# CITY OF ALBUQUERQUE

PLANNING DEPARTMENT – Development Review Services

**RE: Sunset Subdivision  
Drainage Calculations for Reconfigured Lots  
Engineer's Stamp Date 5-6-2014 (File: K12D025)**

PAGE TITLE
Lot 30-P1 Grading Plan

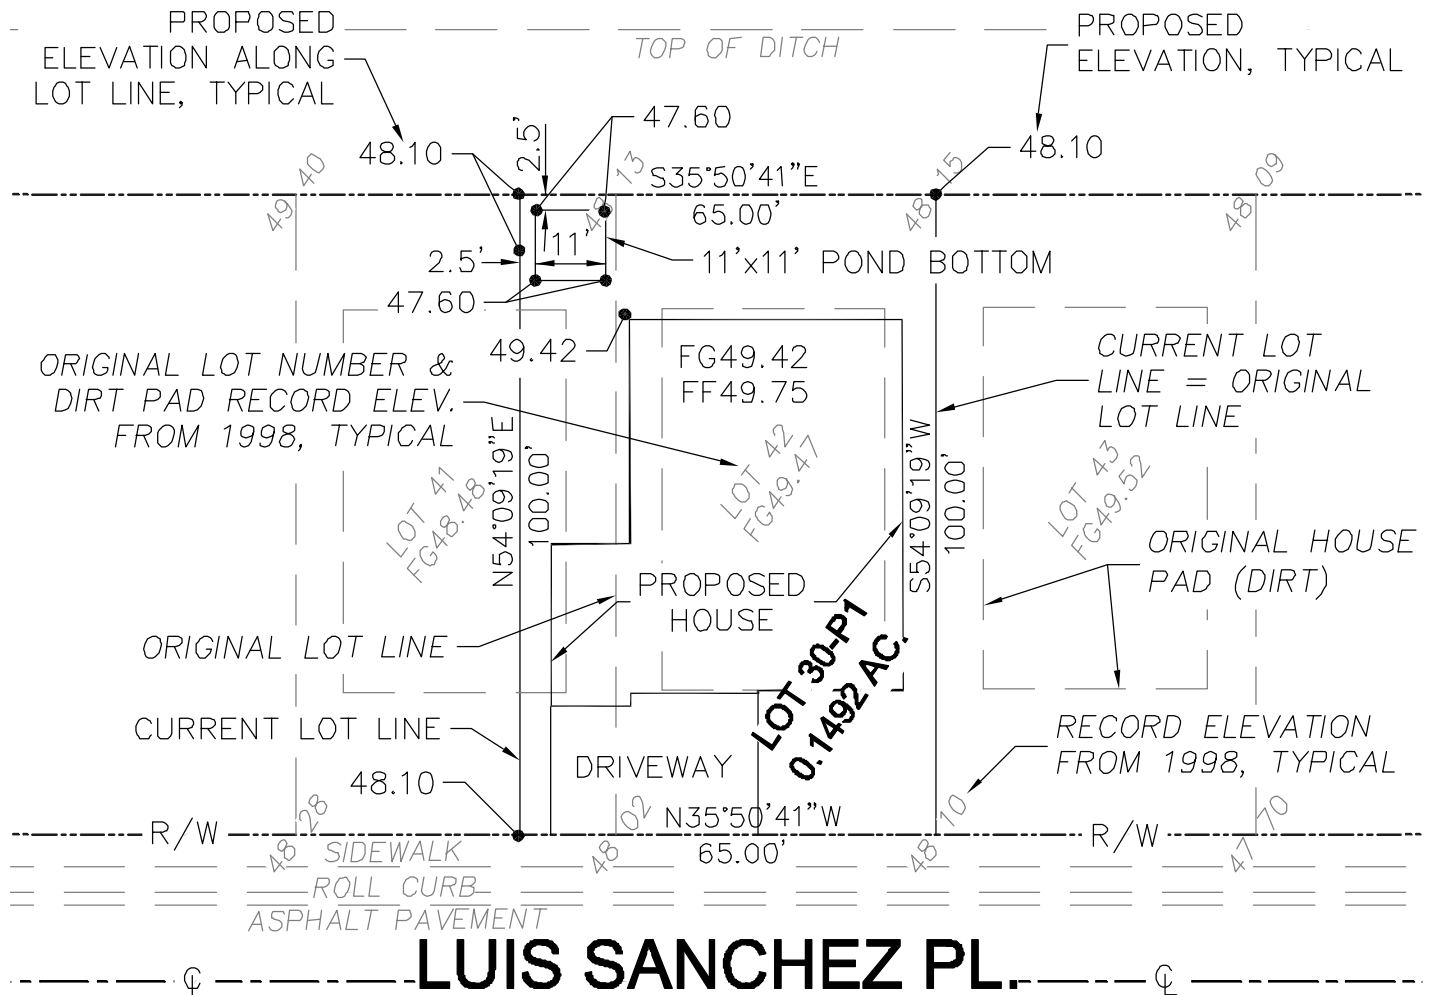
1. Since a Building Permit approval is sought, the appropriate submittal is a Grading Plan showing only the lot for which the permit is sought and the surrounding grades and/or spot elevations. The grading plan should show elevations at all 4 corners of the lot, the Finished Floor elevation, drive pads, and the Pond (showing pond depth).

2. A pond depth of only 1" would not make it identifiable as a pond, and would more than likely be landscaped over in the future. A pond should be clearly identified as such, and be maintained as such.

3. Since the submittal is solely for Lot-30-P1, pond calculations should be based on the amount of impervious area greater than the allowable impervious area (45%) based on the new lot size and not make references to other lots. The volume is the same, but the calculation is much more straightforward and is not dependent on the impervious area of the other lots. This is important for future Building Permits of the other lots.
